**STATION NORTH AND STATION SOUTH SITE WITHIN THE NORTH RYDE
STATION URBAN ACTIVATION PRECINCT (SSD 6265)**

Thank you for your letter dated 8 April 2014 inviting Transport for NSW (TfNSW) to comment on the above. Please accept this as a joint TfNSW and Roads & Maritime Services (RMS) response.

North Ryde Urban Activation Precinct Station Site North and Station Site South

Title
SWEEP PATH ANALYSIS PLAN
Project
**NORTH RYDE STATION SITE NORTH
DEVELOPMENT APPROVAL**

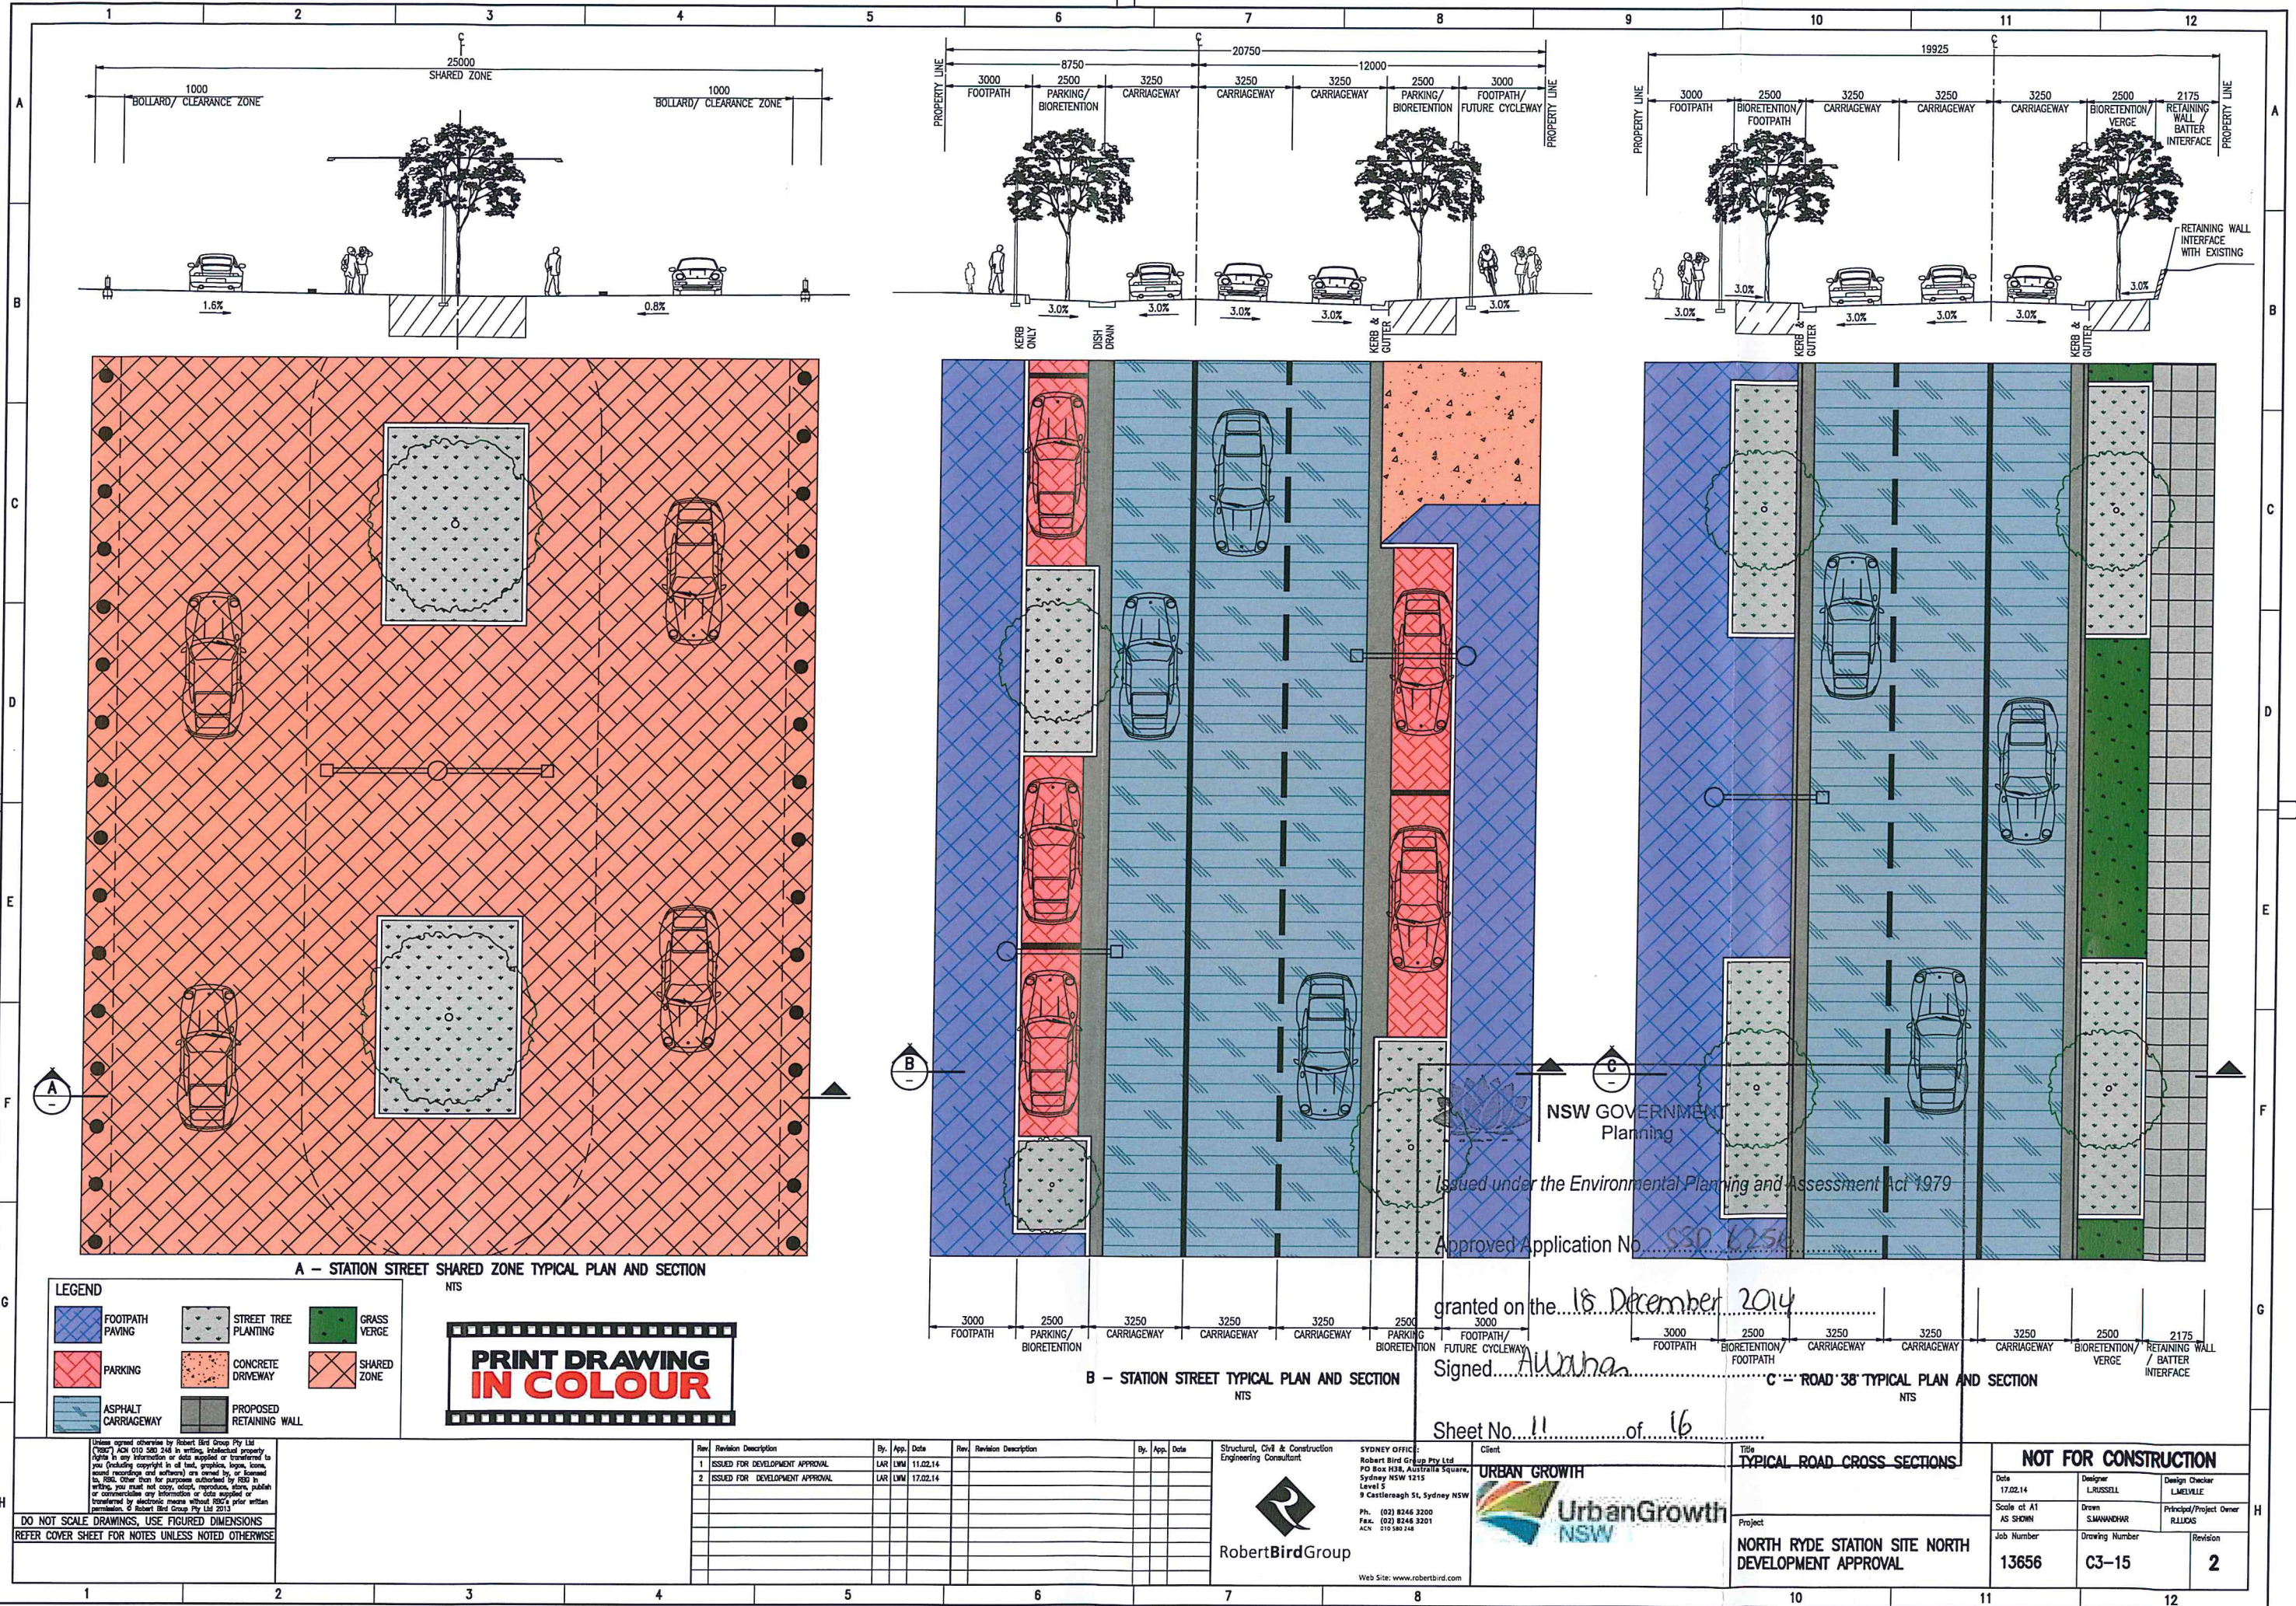
- 2 bedroom apartment – 0.9 space per dwelling
 - 3 bedroom apartment – 1 space per dwelling
 - Visitor parking – 0.1 space per dwelling
3. A commitment from UGNSW and the other development partners that the road network comprising Road 38, Road 18 and Julius Avenue will have swept paths capable of accommodating a 14.5 non rear steer bus. TfNSW also requests that a layover area be provided within the above mentioned road network to accommodate two (2) 14.5m buses with draw in/draw out space and provision of suitable signage or kerb indentation if necessary.

On balance TfNSW is accepting of the UGNSW/Country Garden position that buses cannot now be accepted in Station Street without a range of significant compromises in other areas. TfNSW has indicated it may seek to re-balance services so that more services are directed to the M2 Site while comparatively fewer of the services will be directed to Station Site South. UGNSW should recognise this will increase the need for supporting infrastructure in the M2 Site. This will or may include bus stops, bus layover, driver/toilet facilities and potentially a covering canopy on the pedestrian bridge. UGNSW and their development partners should also commit to recognise the need for the road network comprising Road 38, Road 18 and Julius Avenue to be connected and built to a standard able to accommodate the swept path of 14.5 metre non-rear steer buses. TfNSW also requests that a layover area be provided on these roads to accommodate two (2) 14.5m buses with draw in/draw out space. This will achieve practical achievement of Section 4.1 D of the North Ryde DCP *Ensure connector streets are designed to accommodate movement of buses.*

- An assurance Road 38, Road 18 and Julius Avenue will be provided for bus turnaround inclusive of swept paths for 14.5m non rear steer buses and two bus layover spaces for 14.5 metre buses.
- Bus stops, bus layover, driver/toilet facilities to be committed to in the M2 site. UGNSW to undertake and report on the costs involved in providing a covering canopy on the pedestrian bridge from the M2 Site to North Ryde Station.
